KITTTITAS COUNTY COMMUNITY DEVELOPMENT SERVICES

RE: Daniels Short Plat (SP-08-09)

The Kittitas County Community Development Services Department has determined that the Daniels Short Plat (SP-08-09) is a complete application and hereby grants **conditional preliminary approval** subject to the following conditions:

**DANIELS SHORT PLAT**  
**ALL OF THE S.W. 1/4 OF THE N.W. 1/4 OF THE S.E. 1/4 OF SECTION 8,**  
**TOWNSHIP 19 NORTH, RANGE 16 EAST, W.M.**  
**KITTITAS COUNTY, WASHINGTON**

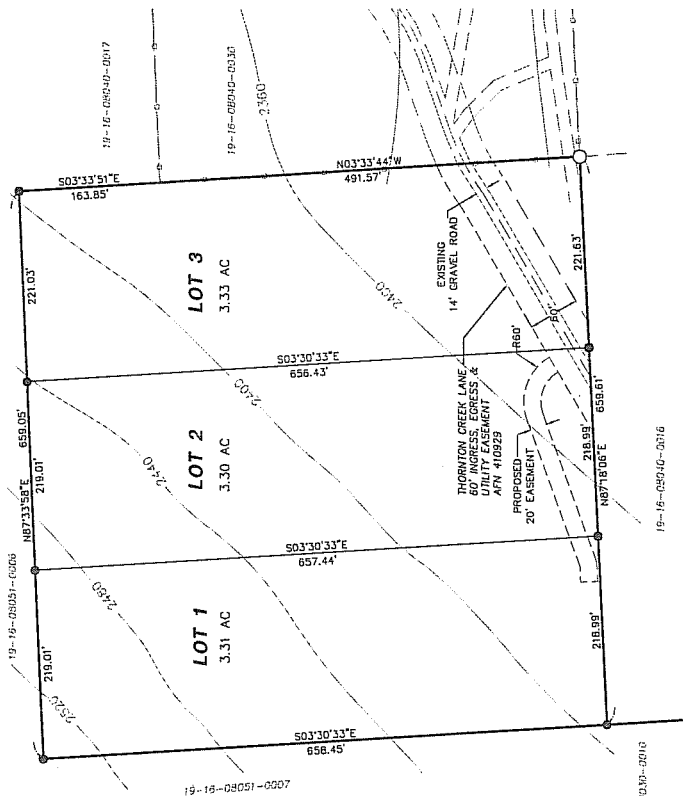
2. Full year's taxes shall be paid on all tax parcel numbers per requirement of the Kittitas County Treasurer's Office.
3. Thornton Creek, a "Type 2" stream, flows through the subject property. The stream shall be shown on the final mylars and its associated 100 foot buffer shall also be depicted.

1. Thornton Creek Lane Access Easement: The AFN (Auditors Recording Number) shall be shown on the face of the plat for the existing Thornton Creek Lane 60' access and utility easement.

5. Access to Lot 1 Joint-Use Driveway: It appears that access to lot 1 is being proposed via the 20' easement as shown on the face of the plat. Access to lot 1 shall be via this joint-use access and shall serve no more than two tax parcels. See Kittitas County Road Standards, 9/6/05 edition.
